From: John Tideswell [REDACTED]
Sent: 21 January 2022 13:20
To: Planning <Planning@arun.gov.uk>; Maria Tomalova <Maria.Tomalova@arun.gov.uk>
Cc: [REDACTED]
Subject: Re: BR/3/22/DOC (99 Victoria Drive, Bognor Regis, PO21 2DZ)

After checking the Arun Planning Portal we have noticed that a new request has been submitted (BR/3/22/DOC) which addresses the conditions imposed by the Planning Inspectorate upon the building work taking place at 99 Victoria Drive, Bognor Regis, PO21 2DZ.

PROPOSED SOUTH WEST ELEVATION

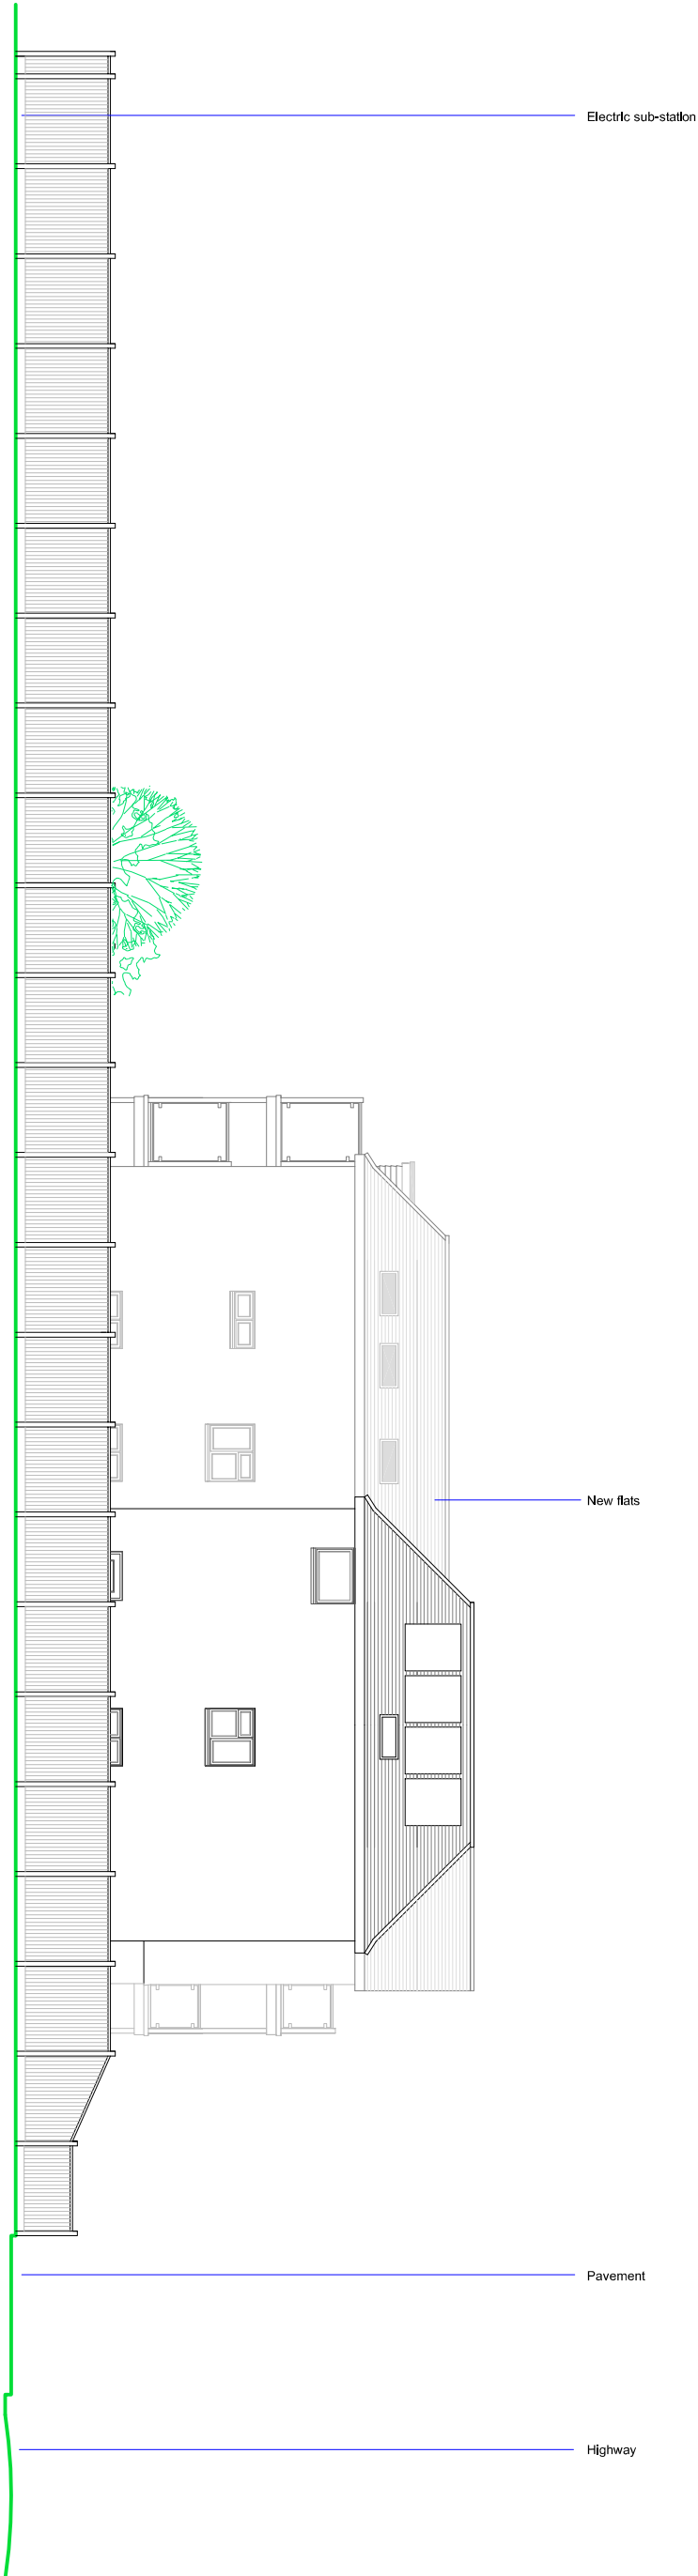
After reading the details under Condition 9 in the applicants covering letter dated 30th December 2021, the new proposal clearly states that the existing brick wall will remain and there will be no additional acoustic fencing placed to protect the properties to the rear (9 and 11 Hillsboro Road) or to the North-East (15 Hillsboro Road). The proposed plan was also checked and this is the case. In my mind this clearly contravenes the request of the Planning Inspectorate, especially as the two semi-detached houses are explicitly mentioned. Our opinion is acoustic panelling is as important at the rear of the property as the side as cars will be starting, idling and driving at the rear of the property.

As emphasised in our previous correspondence regarding BR/281/18/PL, we are not trying to prevent this development taking place, but in the grand scheme, we do not see that fixing the wall and adding additional acoustic fencing to the North and to the North-East of the property would be a significant undertaking for the developer.

PROPOSED SITE/LANDSCAPE PLAN

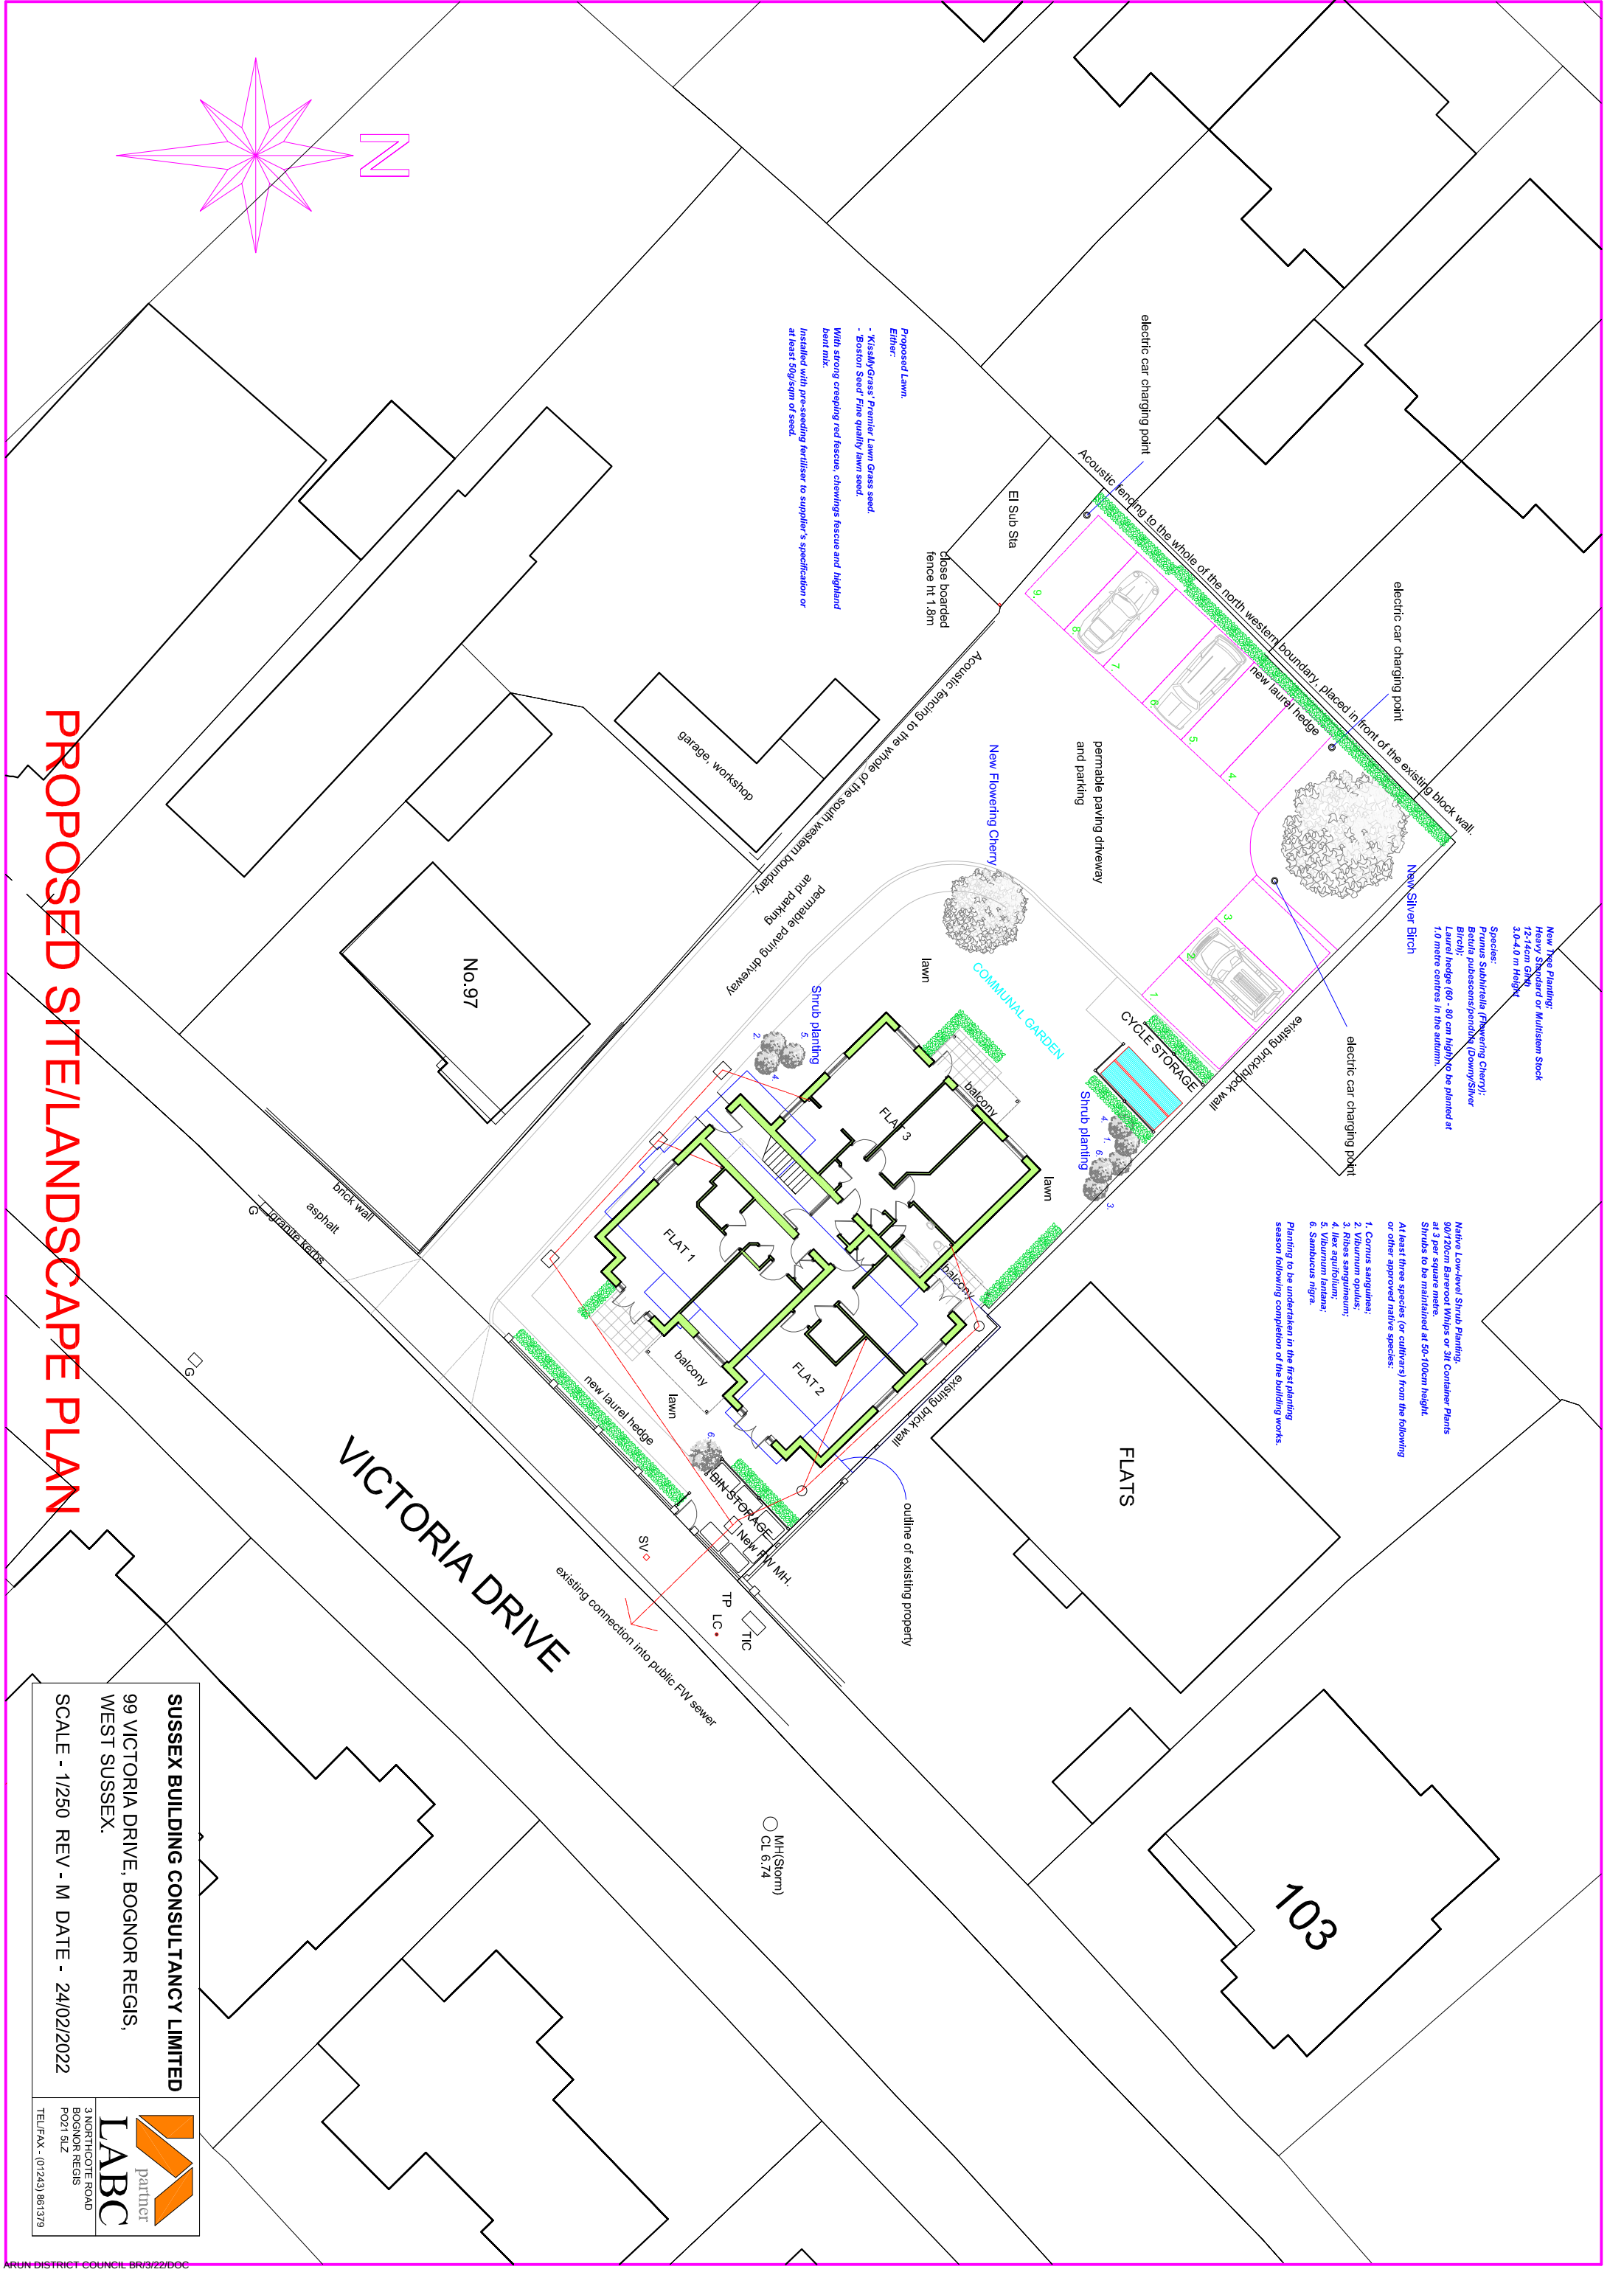
14. As presently submitted the appeal scheme does not do this adequately. For example, on the Proposed Site Plan the boundary with Nos. 97 & 95 is simply labelled 'acoustic fencing' and the rear boundary with the pair of semi-detached houses in Hillsboro Road shows the retention of the existing concrete block wall and the planting of a hedge. I do not consider that enough thought has been given to the safeguarding of neighbours from the effects of car parking, including noise and headlights, and this deficiency if it remained would warrant dismissal of the appeal.

We also raised concerns as to the integrity of the wall at the rear and side of the properties on Hillsboro Road. As previously mentioned, a part of the wall between 99 Victoria Drive and 15 Hillsboro Road has already collapsed and the wall at the end of our property (11 Hillsboro Road) is not structurally sound. We are concerned for the safety of our child who often plays near the rear wall.
